# CITY OF PORTLAND BUILDING PERMIT

Job ID: 2011-05-971-ALTCOMM

has permission to Renovate Bldg, Core and Shell/MEP, bathrooms/elevator. No exterior changes approved, Retail-1<sup>st</sup>/offices provided that the person or persons, firm or corporation accepting this permit shall comply with all of the provisions of the Statues of Maine and of the Ordinances of the City of Portland regulating the construction, maintenance and use of the buildings and structures, and of the application on file in the department.

**A1.01**

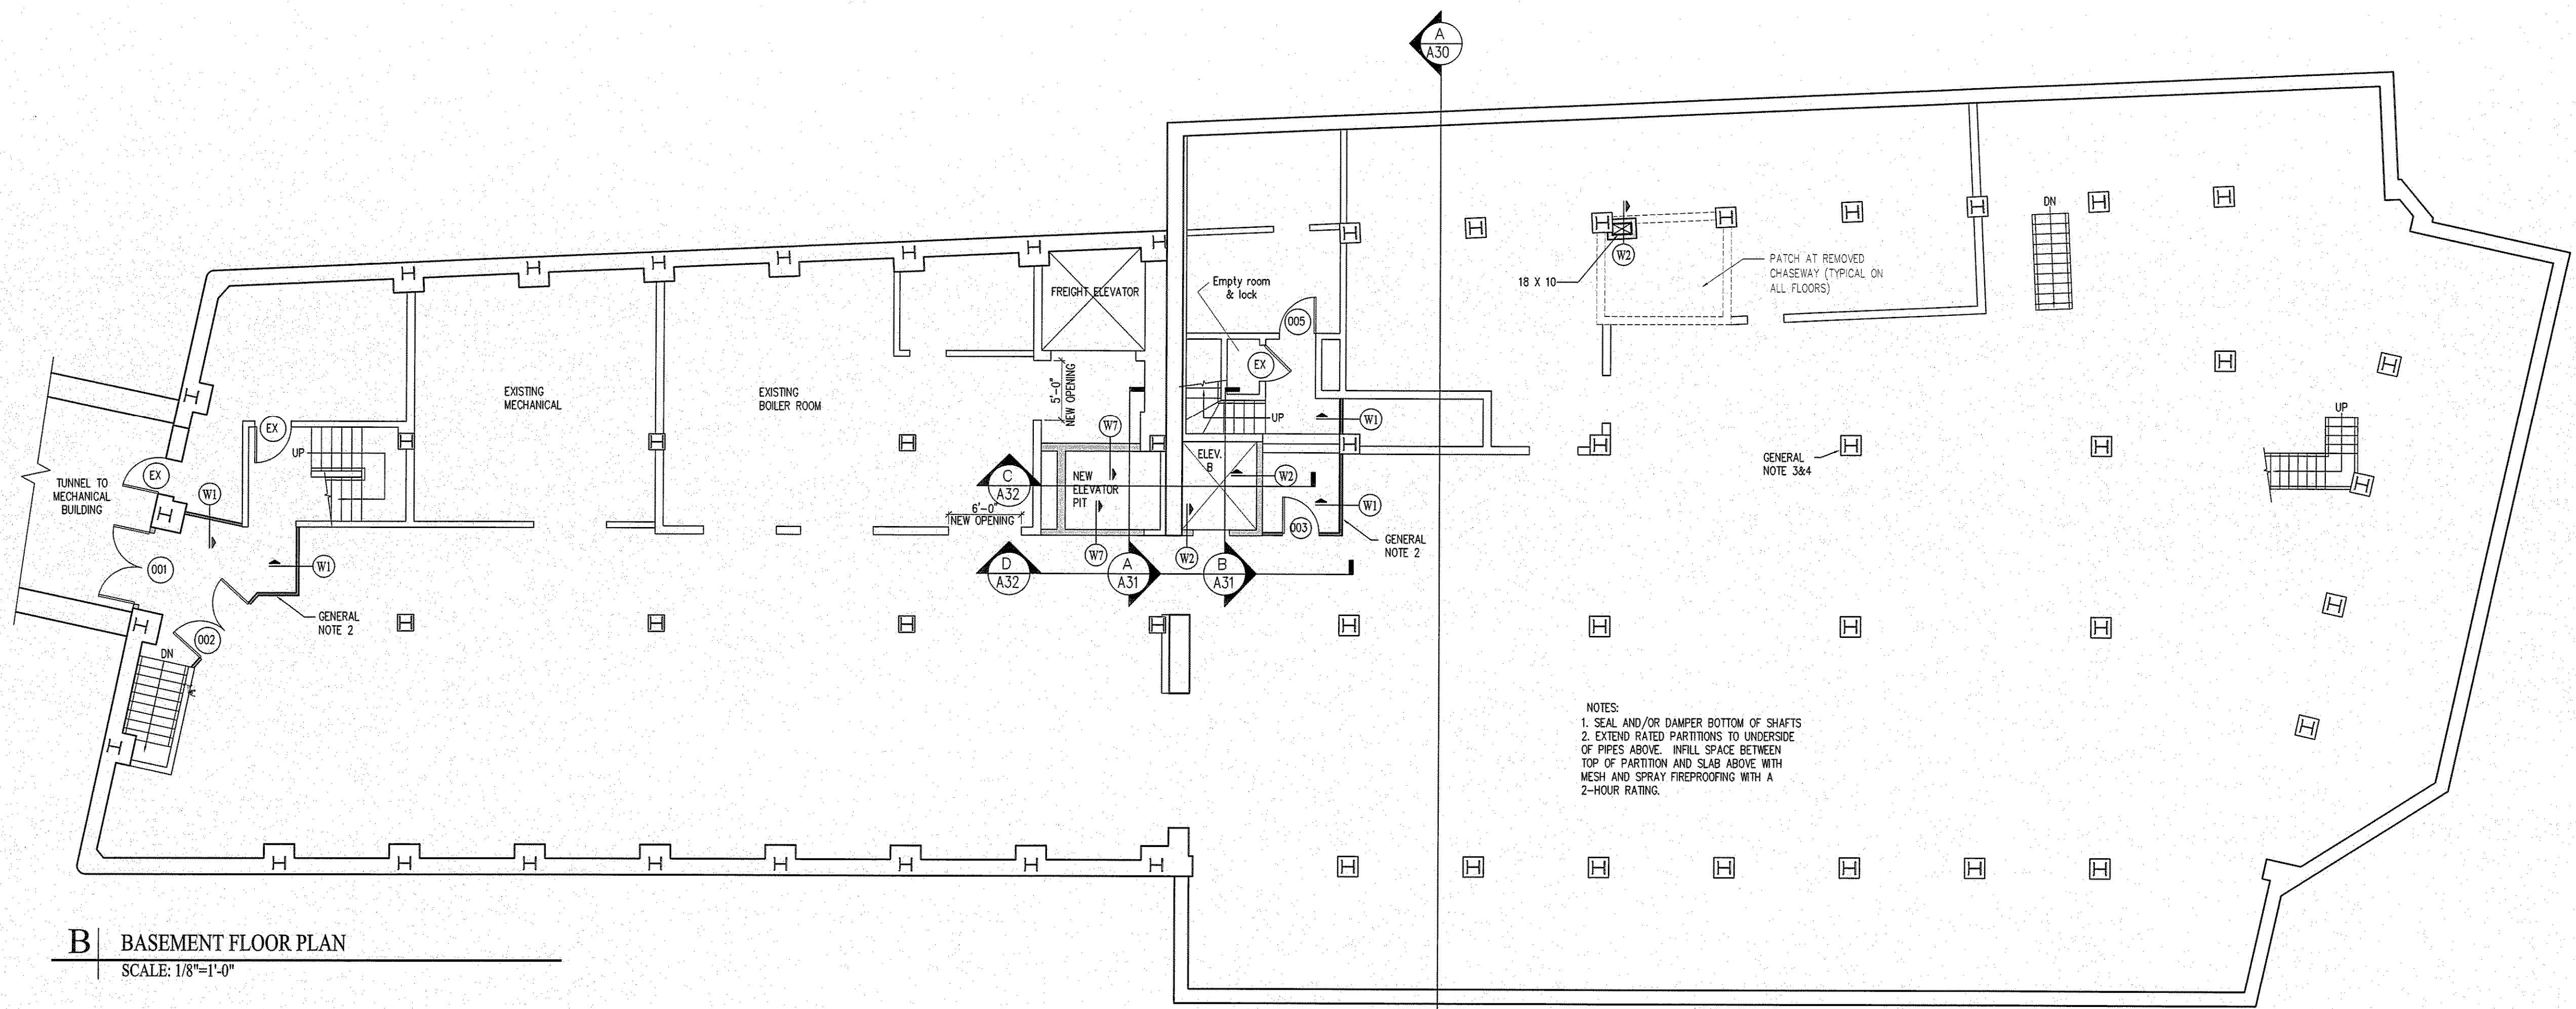
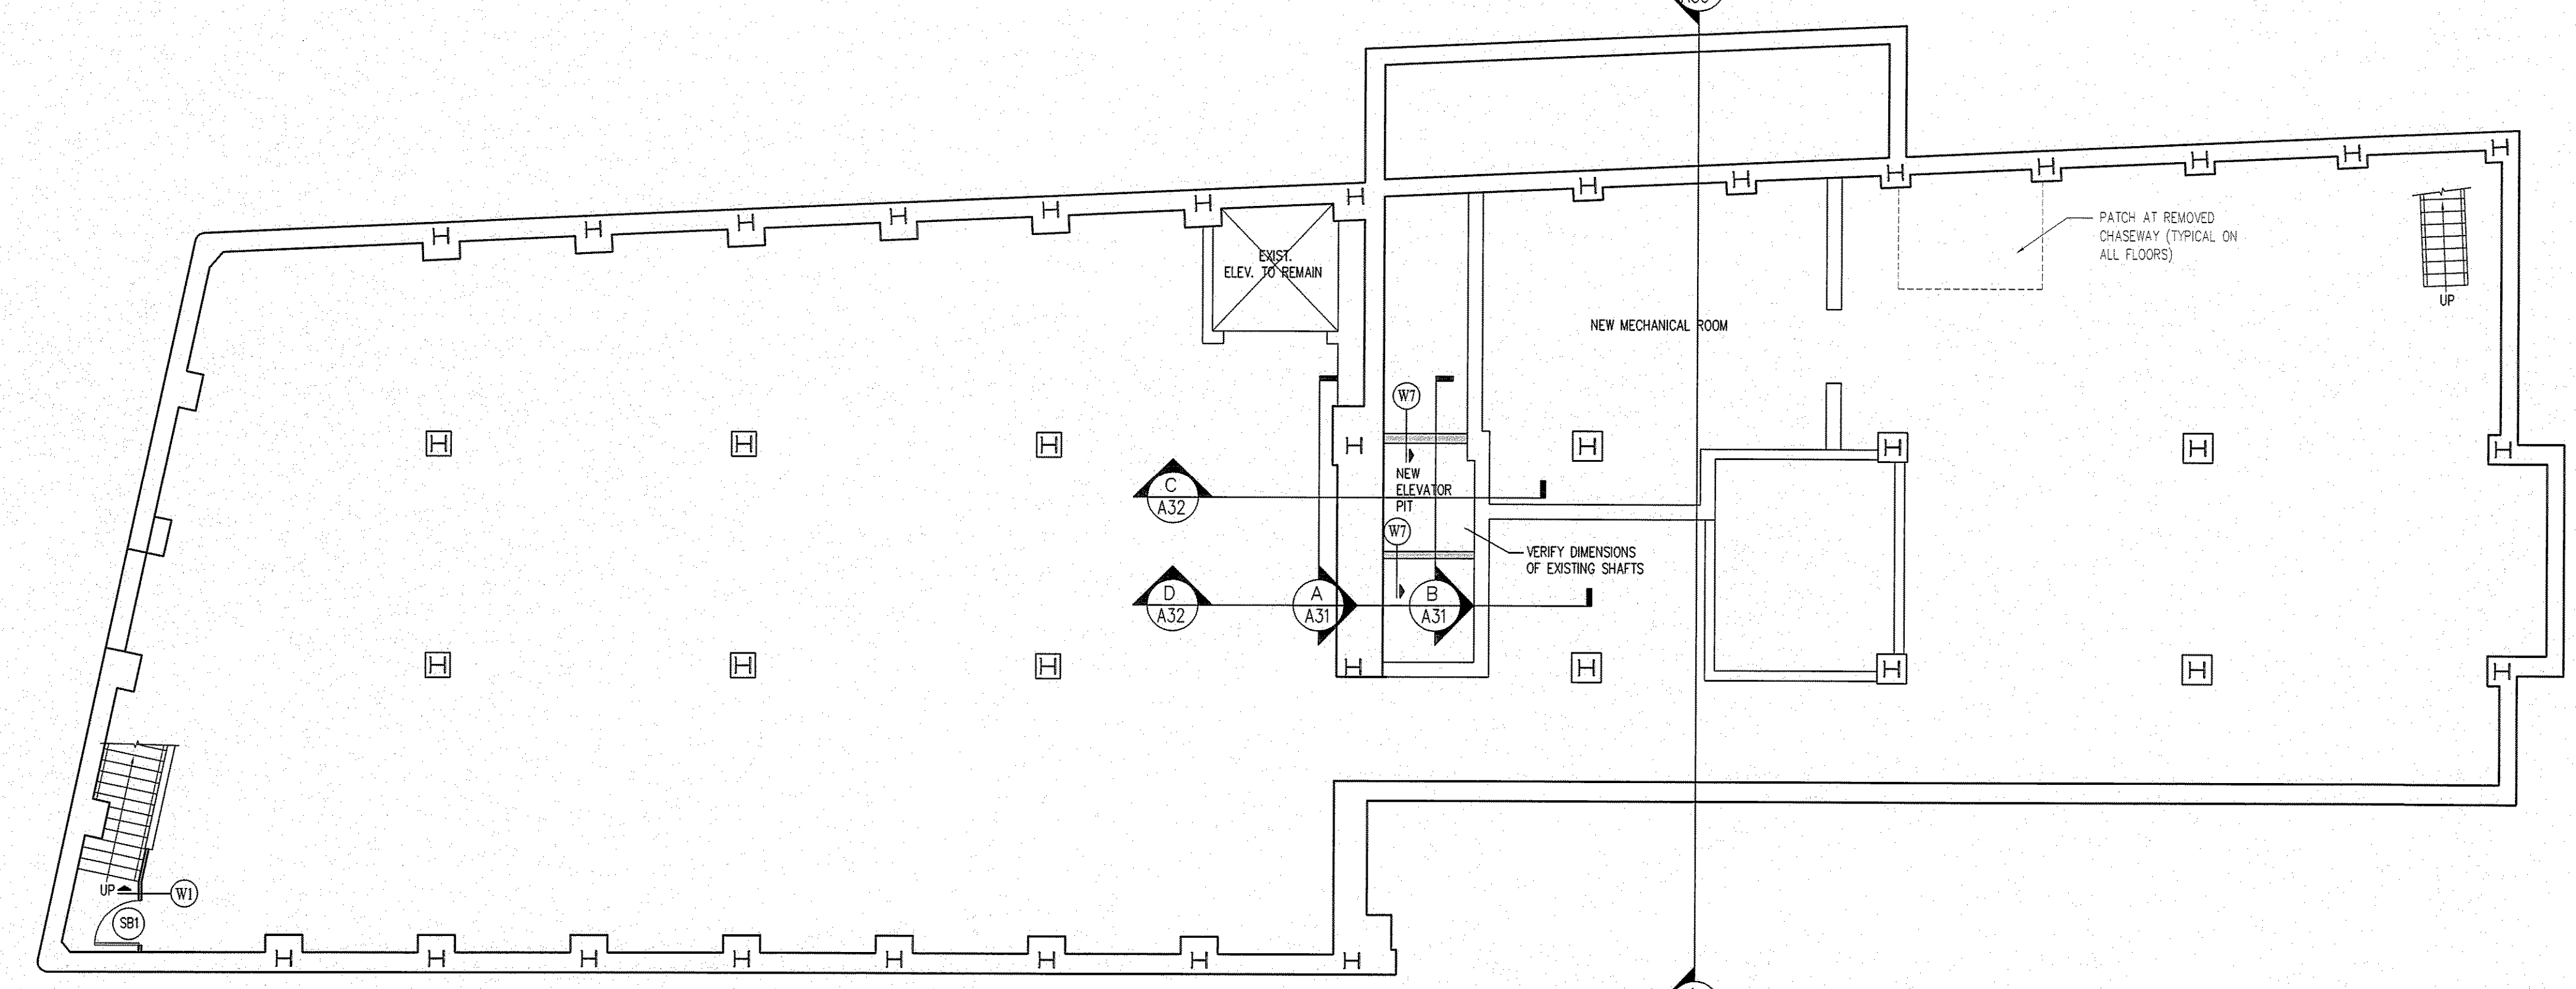
1. All building shall comply with City Code Chapter 10.
2. The stairs at the basement and sub-basement levels shall be enclosed in accordance with Chapter 7 of the *Life Safety Code*.

I apologize for not including the third and fourth floor structural plans in the permit set. I have provided the missing sheet as well as the revisions as requested. Drawing SK 01 shows a new enclosure at the sub-basement stair per review of Captain Gautreau, and SK 02 shows the revised access to the fire escape. Please contact Bill with any questions.
